## OFFICIAL NOTICE OF DECISION

CITY OF ALBUQUERQUE  
PLANNING DEPARTMENT  
DEVELOPMENT REVIEW BOARD

**Project# 1009046**

12DRB-70115 MAJOR - PRELIMINARY PLAT APPROVAL

PRELIMINARY PLAT FOR  
**SAWMILL CROSSING**  
**UNIT 1**  
WITHIN THE  
TOWN OF ALBUQUERQUE GRANT  
PROJECTED SECTION 7  
TOWNSHIP 10 NORTH, RANGE 3 EAST, N.M.P.M.  
CITY OF ALBUQUERQUE BERNALILLO COUNTY, NEW MEXICO  
MARCH, 2012

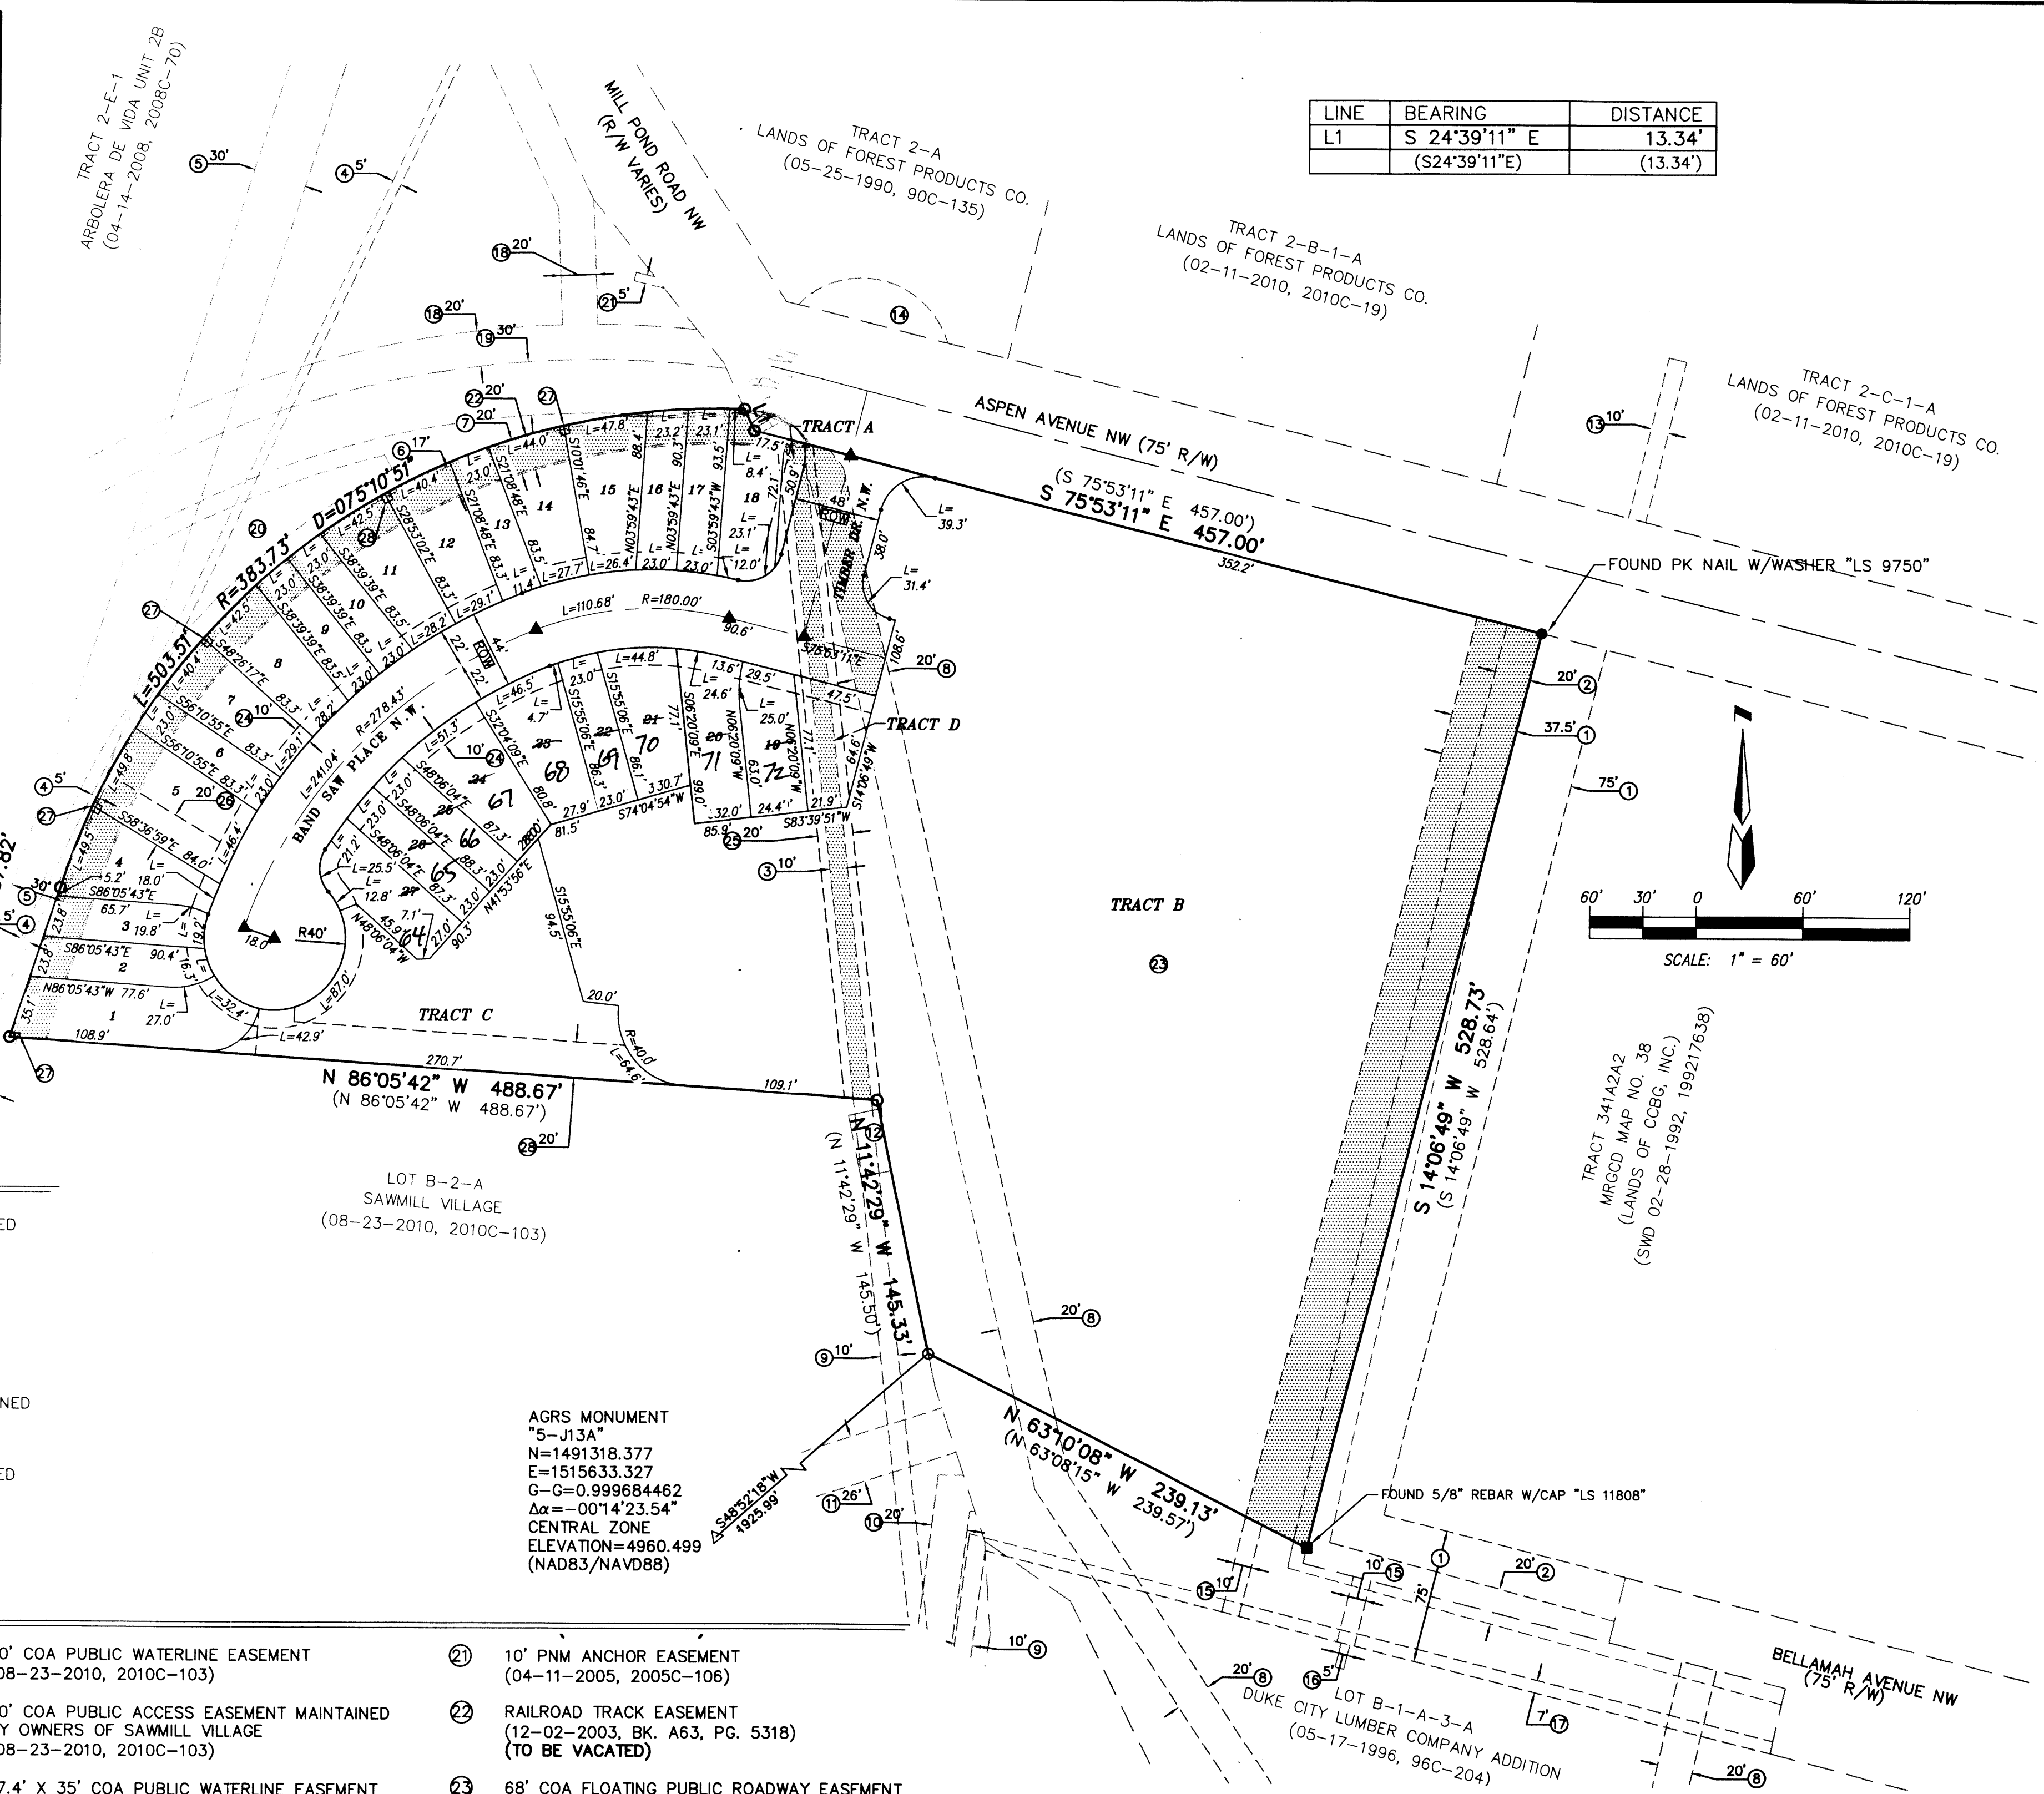
- The Tri-Party Agreement between the developer, the City of Albuquerque, and the NMDOT is required prior to Final Plat.
- The railway crossing must be approved prior to Final Plat.
- Note 9: Show the 3 foot easement on Tract B and it will also be required to be shown on Tract C on the Final Plat.
- Note 10: The sidewalk culverts should be maintained by the property owner on the lot where the sidewalk culvert is built. Change the note by ending the sentence after the word "...owner" on the Final Plat
- A recorded SIA is required prior to applying for Final Plat.
